MMC: FW: Shaws TCP (CMP)

Attached are our responses to the DPW's comments. Our approximate durations for each phase of work are as follows. Let me know if you would like any additional information.

Phase 2 Work Zone  
Traffic Control Plan

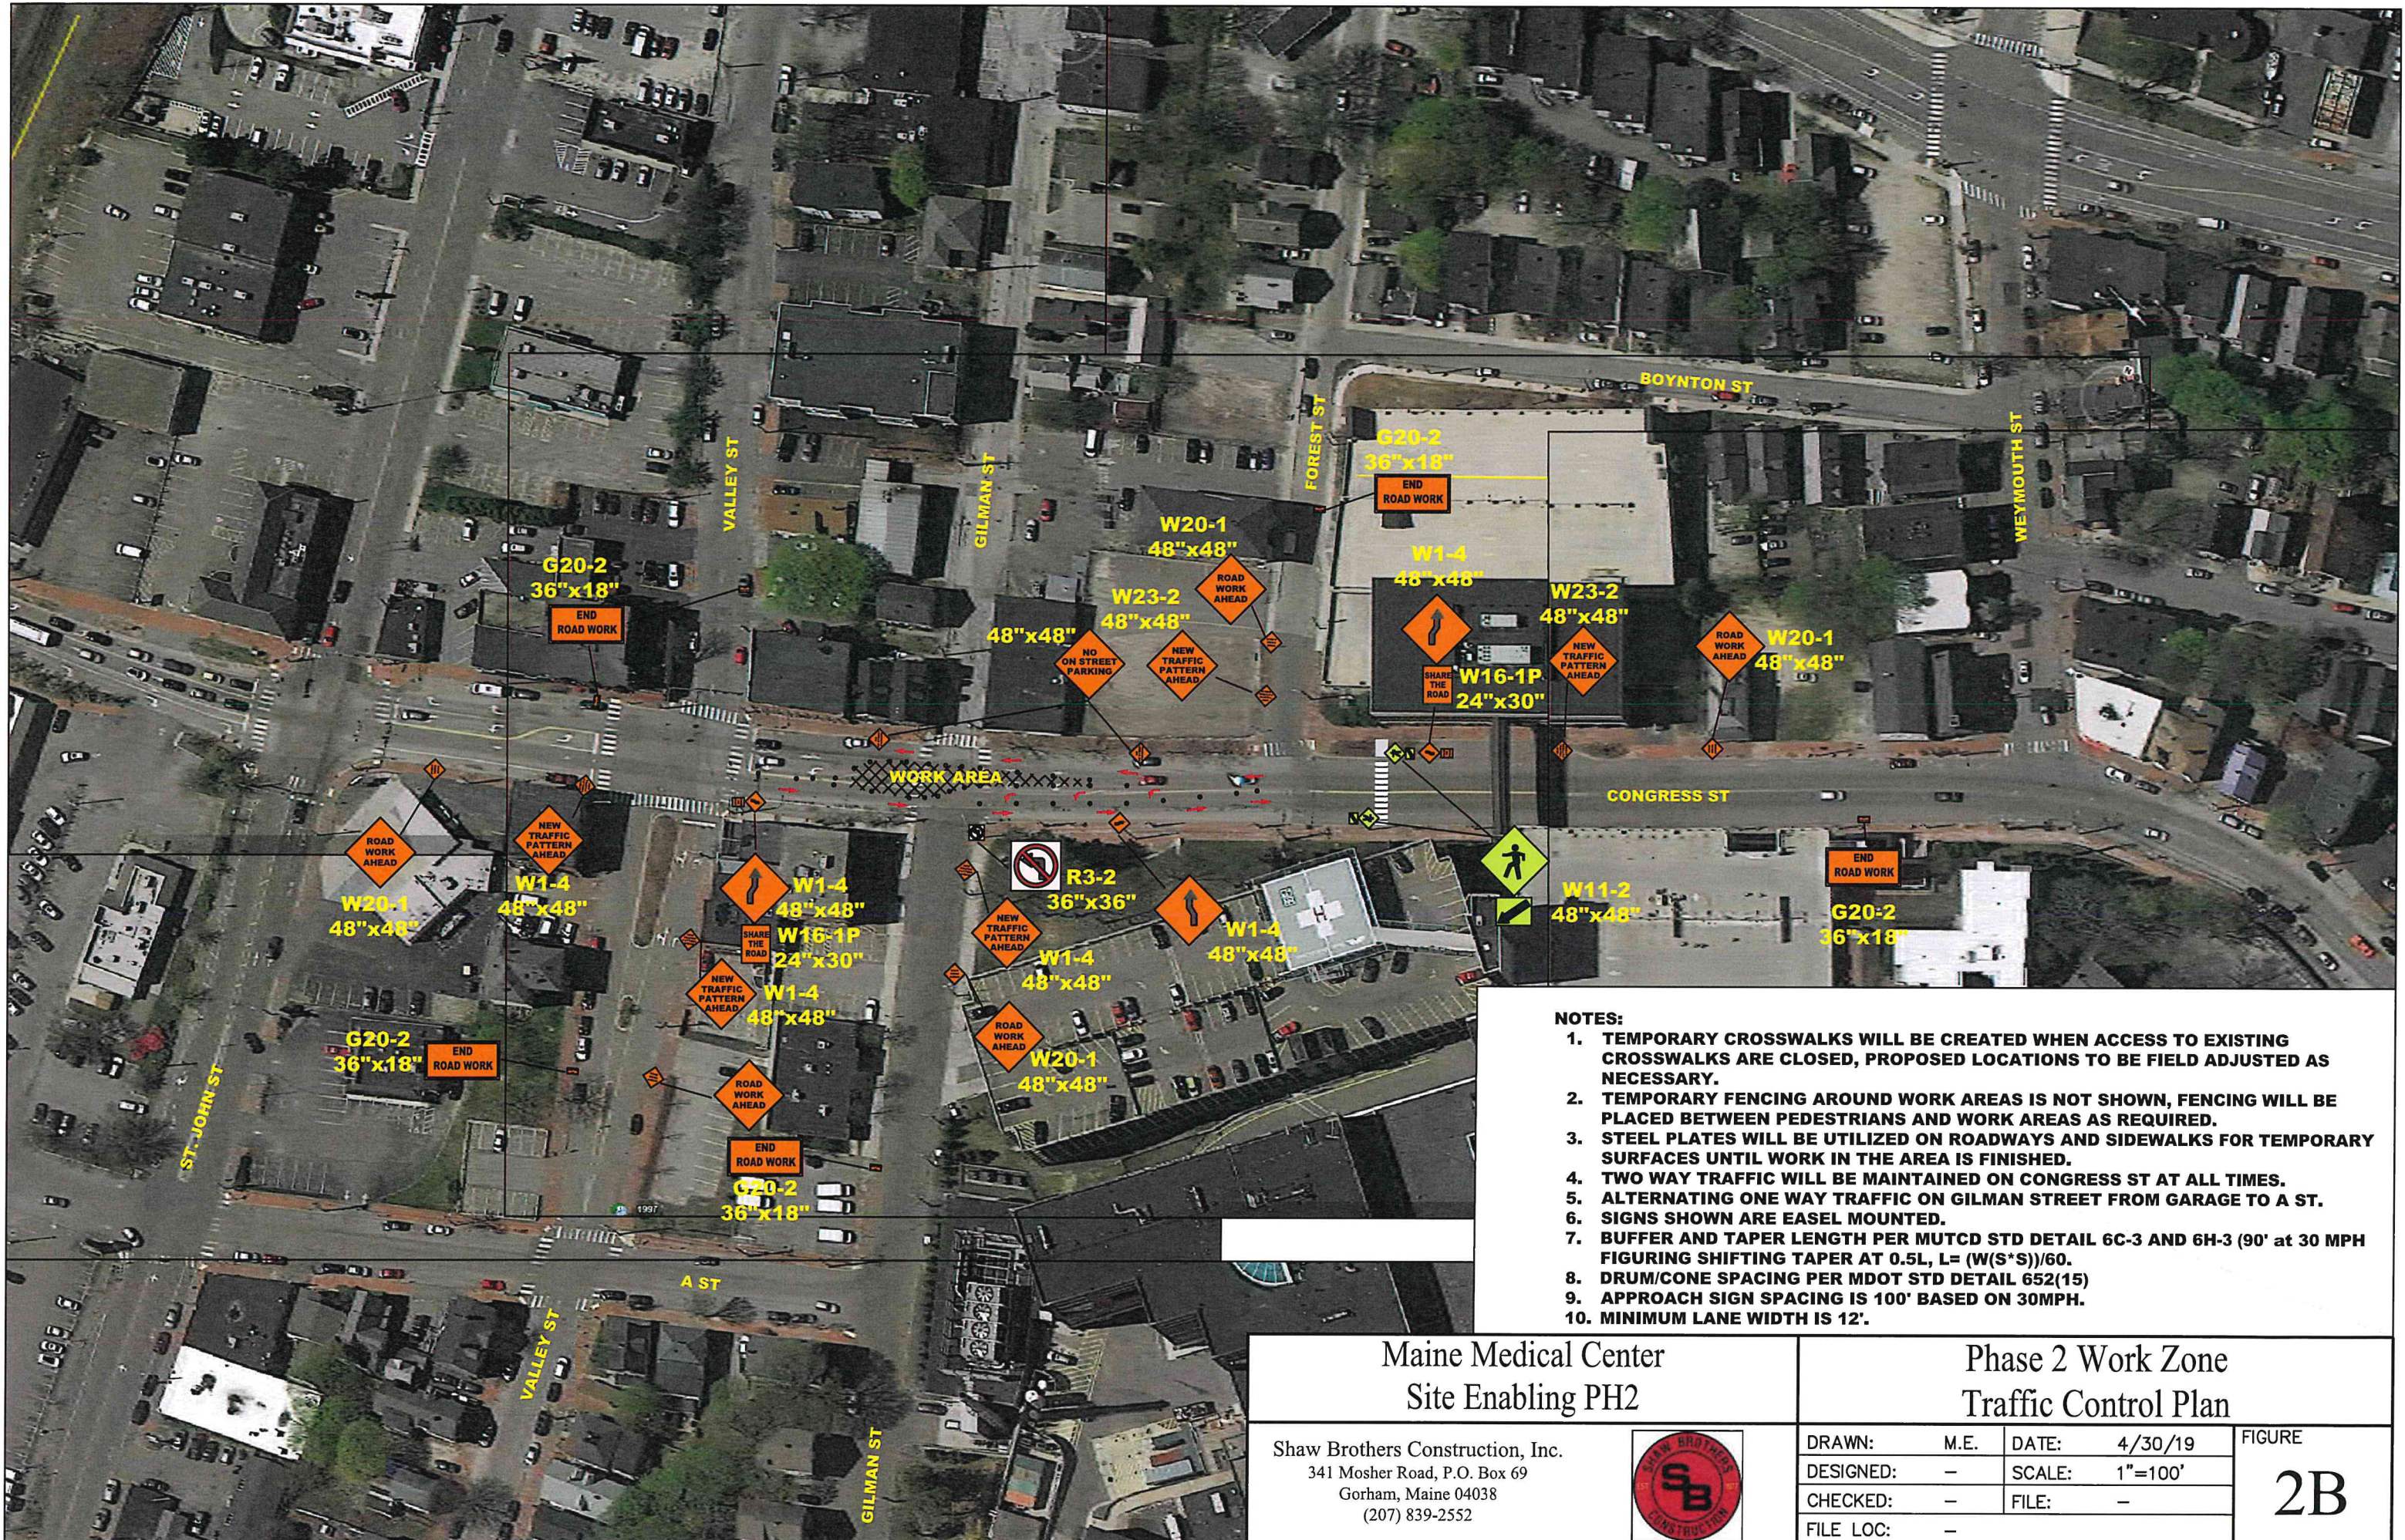
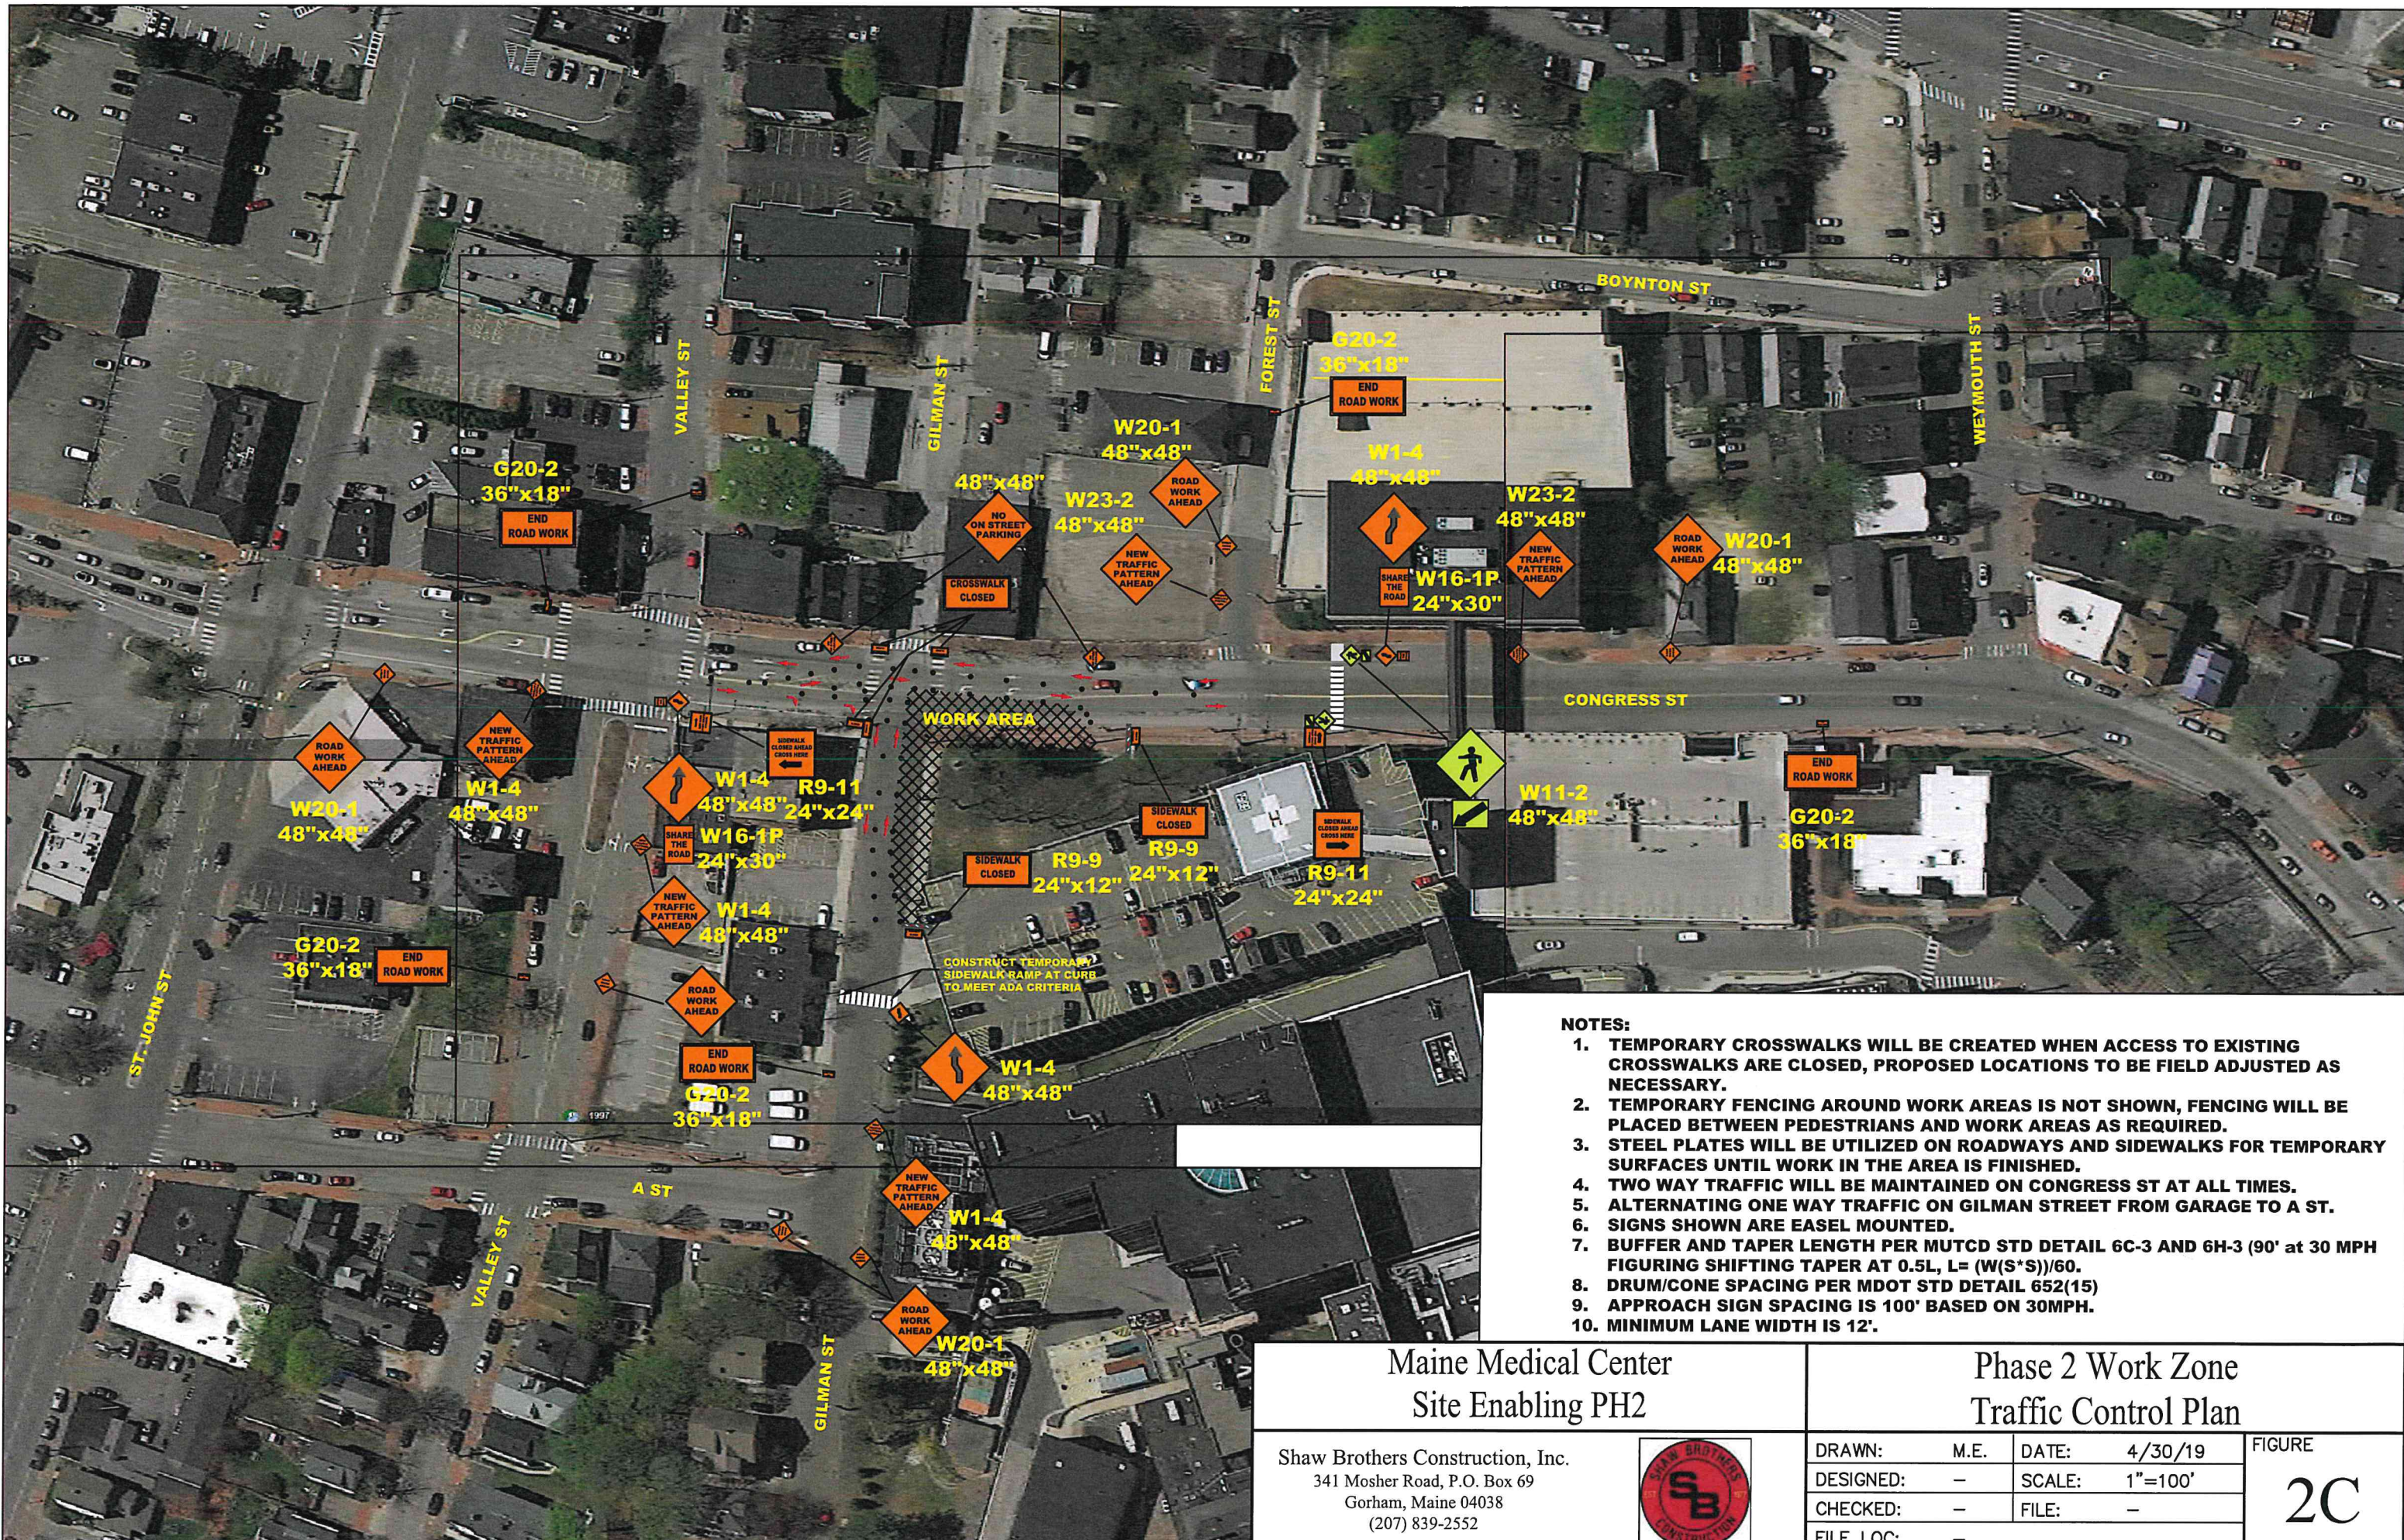
One basic comment from Tom Errico was re labeling the Shaw graphics with approximate timelines, but I don't believe this has been addressed (unless I'm missing something?). We do have timelines in the Turner documents, but these don't match up entirely with these plans. Can you guys address this quickly?

Phase #1: 3-4 weeks

Phase #2: 8-10 weeks

Phase #3: 4-6 weeks
